Rezoning Transportation Analysis

Petition Number: 2020-042

General Location Identifier: Tax ID 14901223

Revision Log:

SHEET NUMBER:
RZ-1

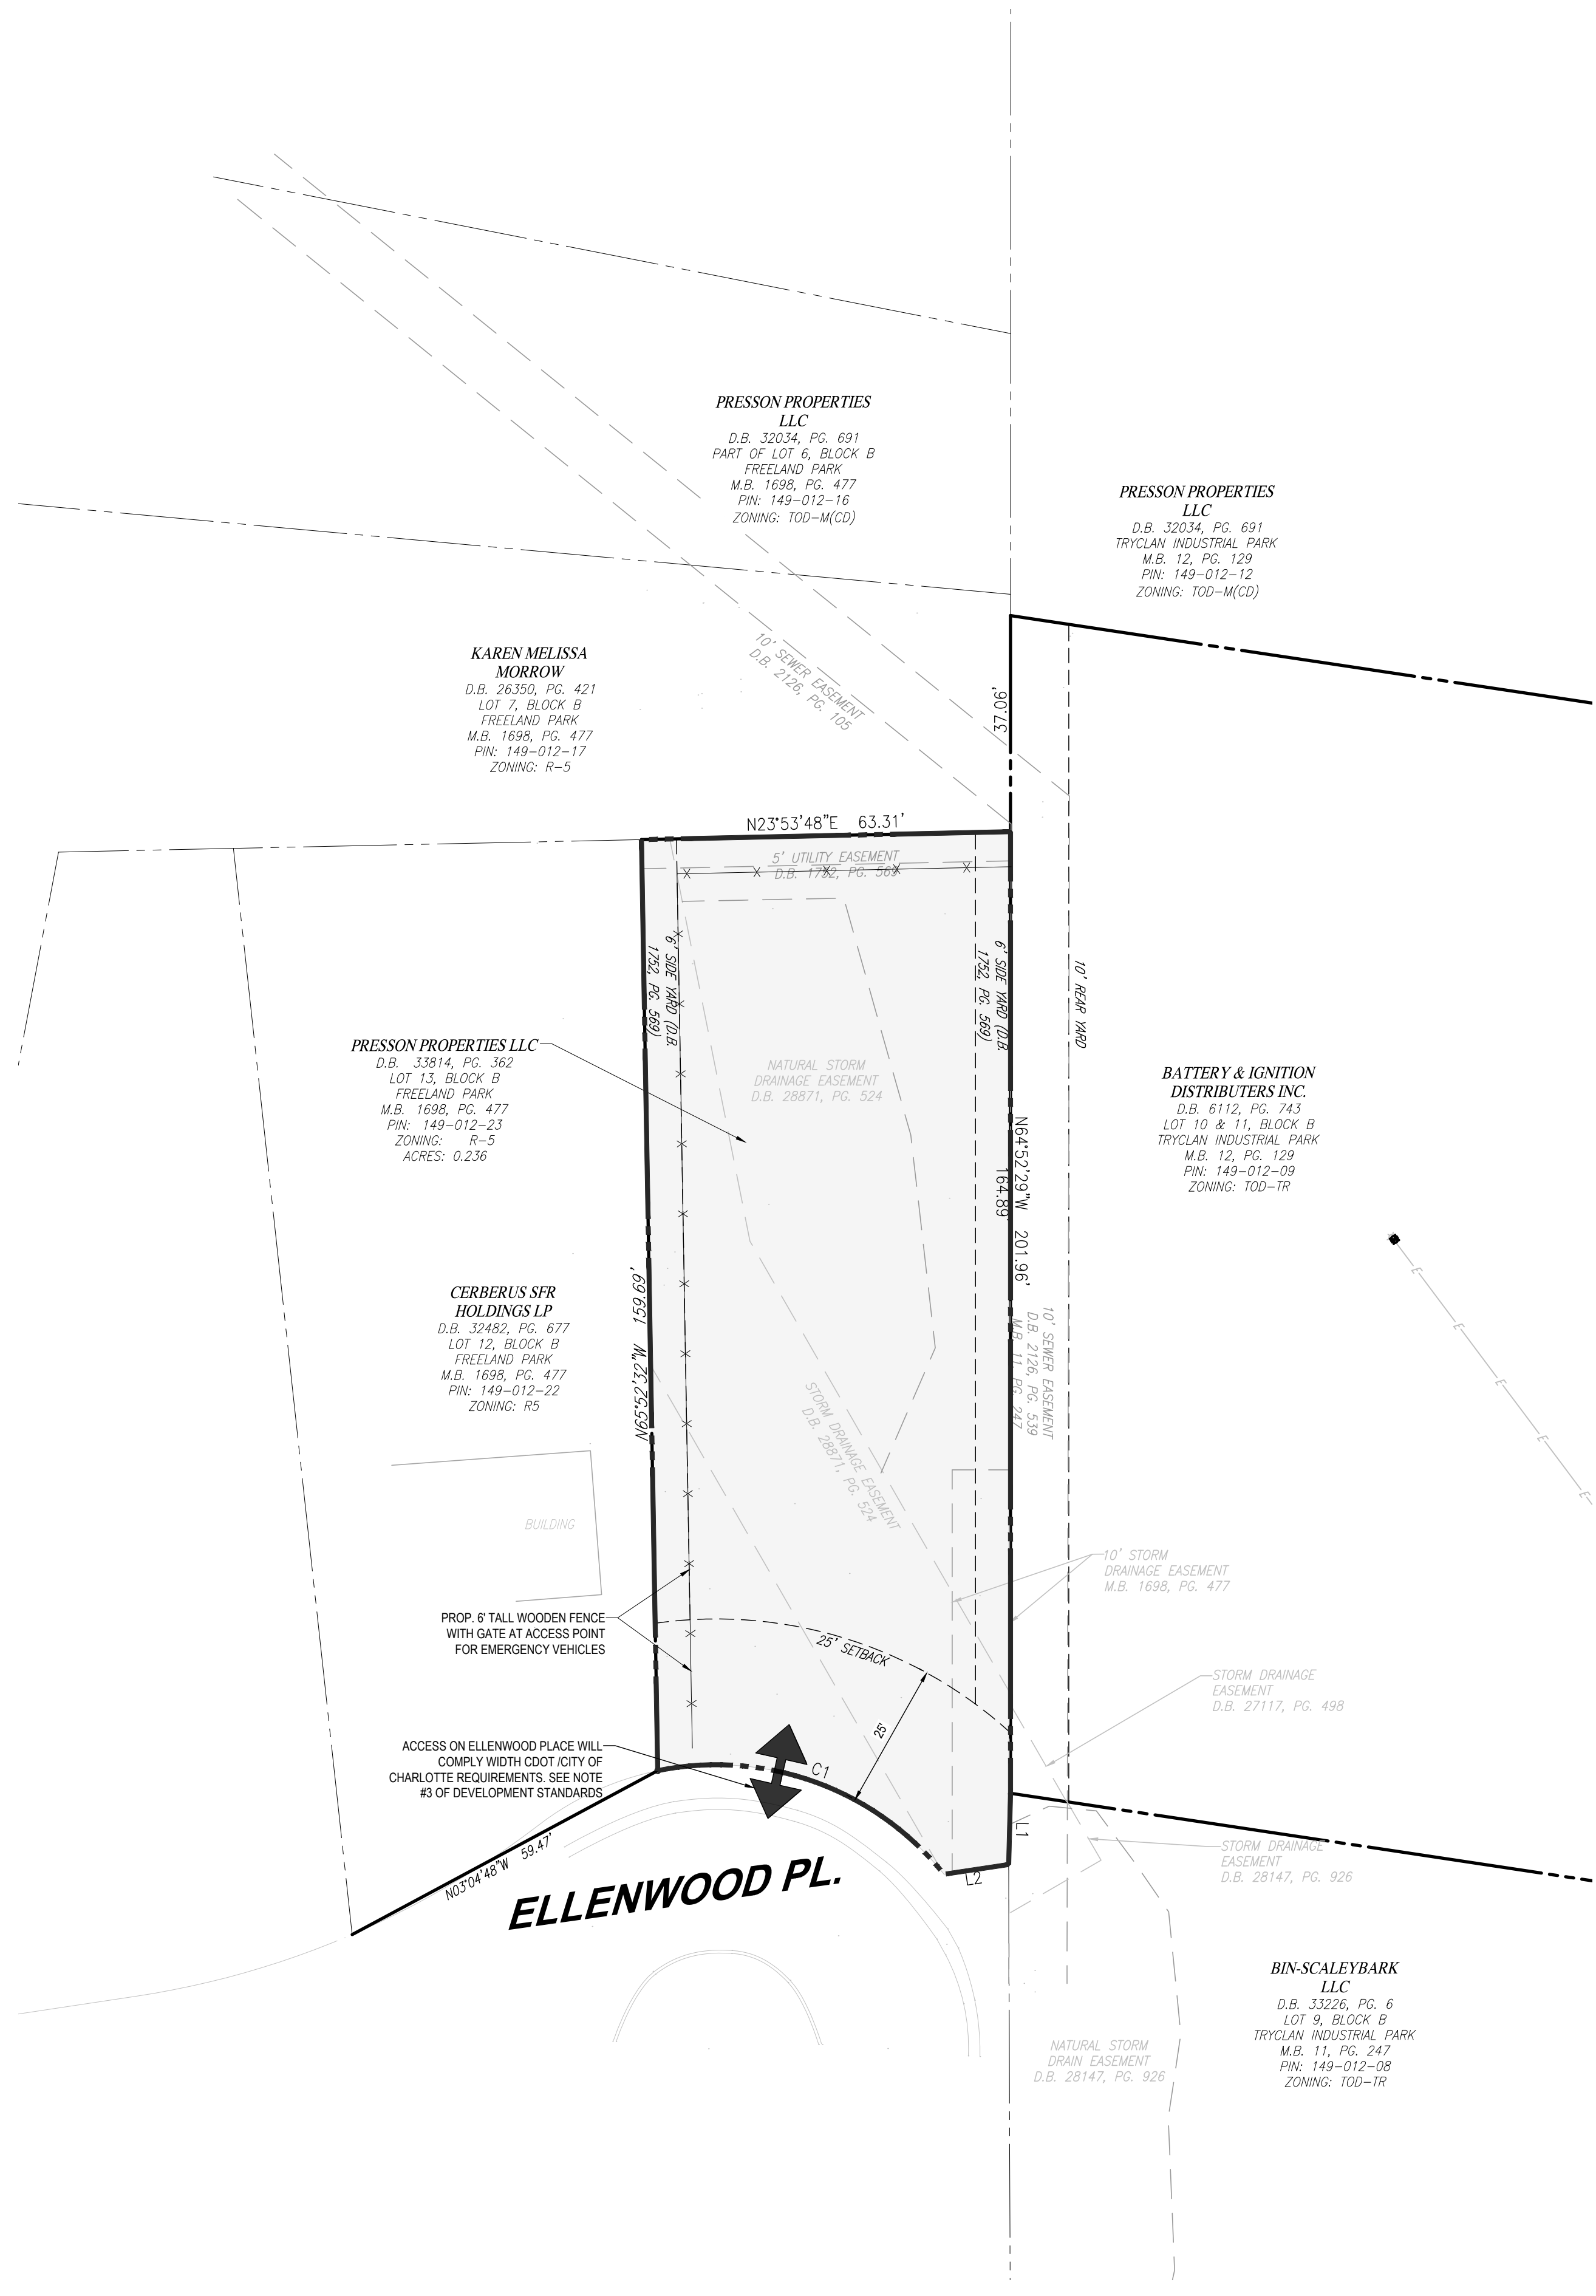
The site is within ¼ mile of Scaleybark Transit Station. There is existing curb and gutter on Ellenwood Place, but no sidewalk. CDOT will work with the petitioner during the permitting to upgrade the streetscape in accordance with City ordinances and to develop a street network that accommodates the surrounding TOD and residential zoning districts. CDOT requests turning movements will be provided for the access drive on Ellenwood Place.
